PLANNING CONSULTATION RESPONSE

Application No	2025/0283
Proposal	Outline consent (all matters reserved) for the demolition of existing garages and erection of one detached dwelling (Custom/self -build) (Amended documentation).
Address	66 Longfields Crescent, Hoyland, Barnsley, S74 9JA
Date of Consultation Reply	05/02/26
Consultee	Highways DC

SITE PLAN

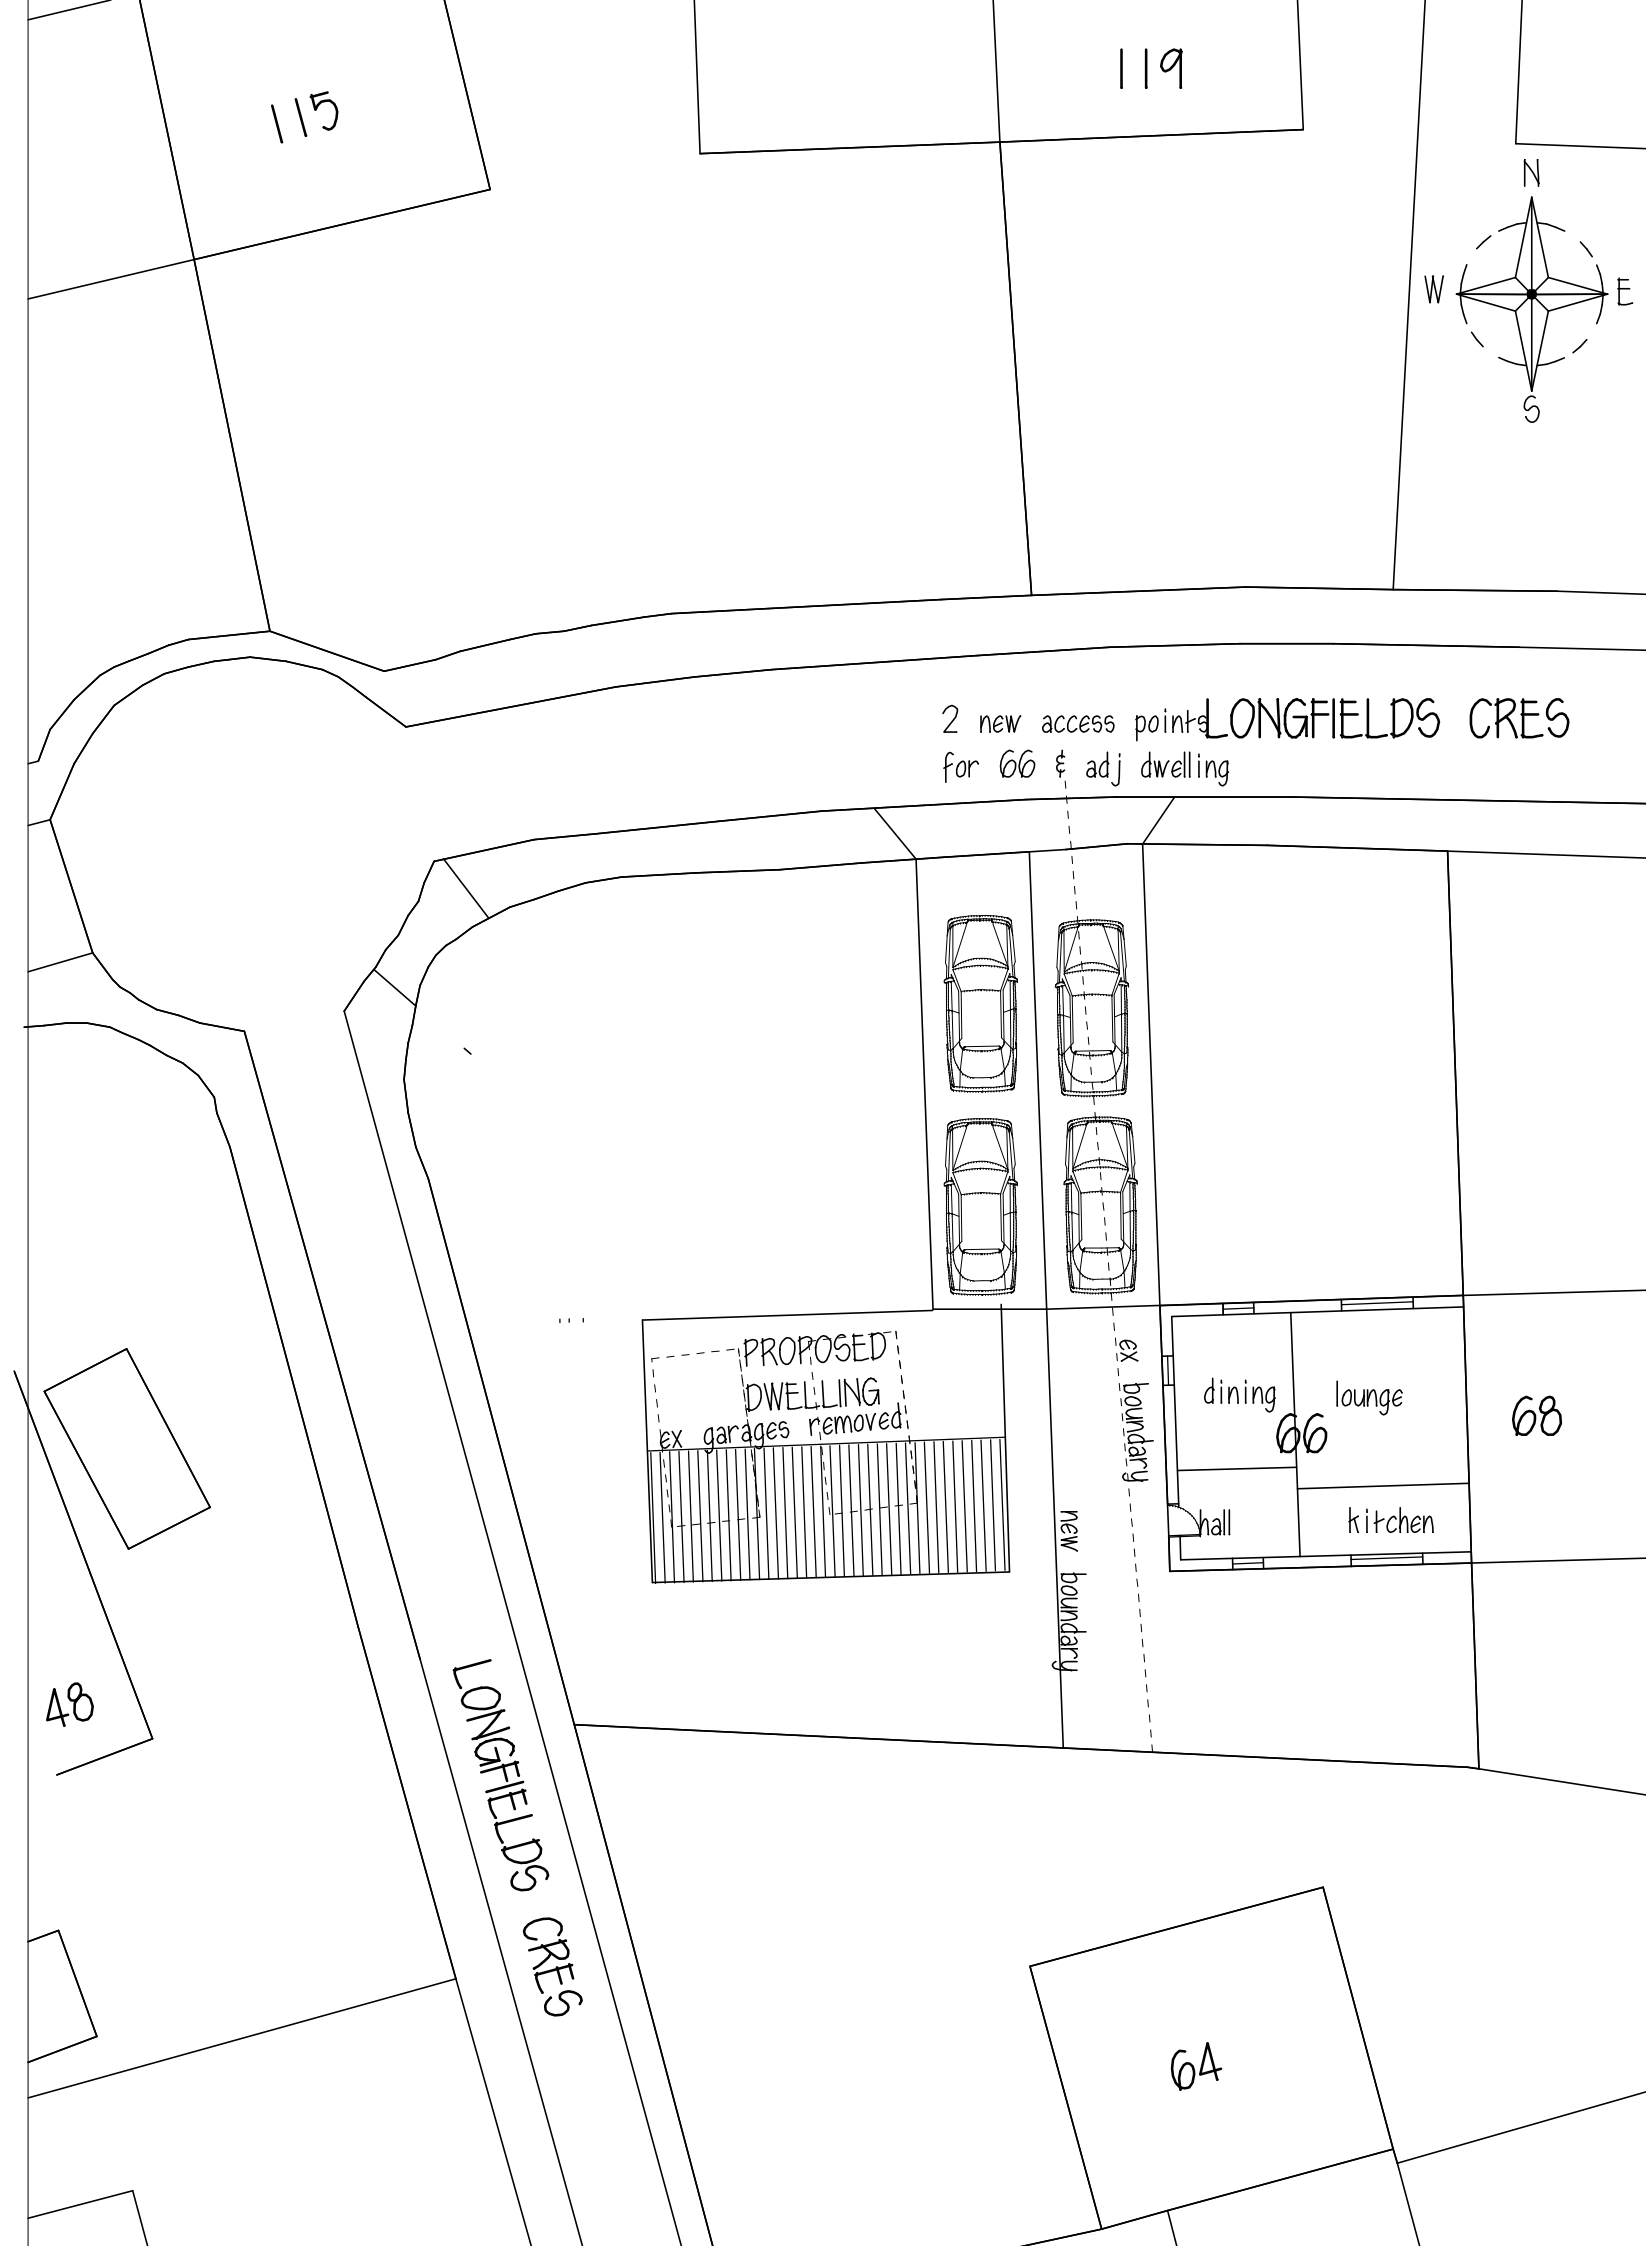
The submitted drawing now shows a single dwelling rather than the pair of semi-detached properties originally submitted. Off-street parking is still demonstrated for both the existing and proposed dwelling in line with the Councils' Supplementary Planning Document (SPD) Parking (2019). This therefore remains acceptable to HDC officers.

The access and parking facilities, as indicated on the submitted plan, shall be surfaced in a solid bound material (i.e. not loose chippings) and made available for the access and parking of motor vehicles prior to the development being brought into use, and shall be retained for said purposes at all times. Adequate measures shall be so designed into the proposed vehicular areas to avoid the discharge of surface water from the site on to the highway.

Boundary treatments to the front of the site shall be set at a height no greater than 900mm above the level of the near side channel line of the public highway and shall be maintained free of obstruction above said height at all times thereafter for the lifetime of the development.

Prior to the development being brought into use, the vehicular accesses shall provide pedestrian visibility splays of 2m x 2m to the back edge of the footway. Nothing shall be erected, retained, planted and/or allowed to grow at or above a height of 0.6m to the rear of the footway which would obstruct the visibility splays. The visibility splays shall be maintained free of obstruction at all times thereafter for the lifetime of the development.
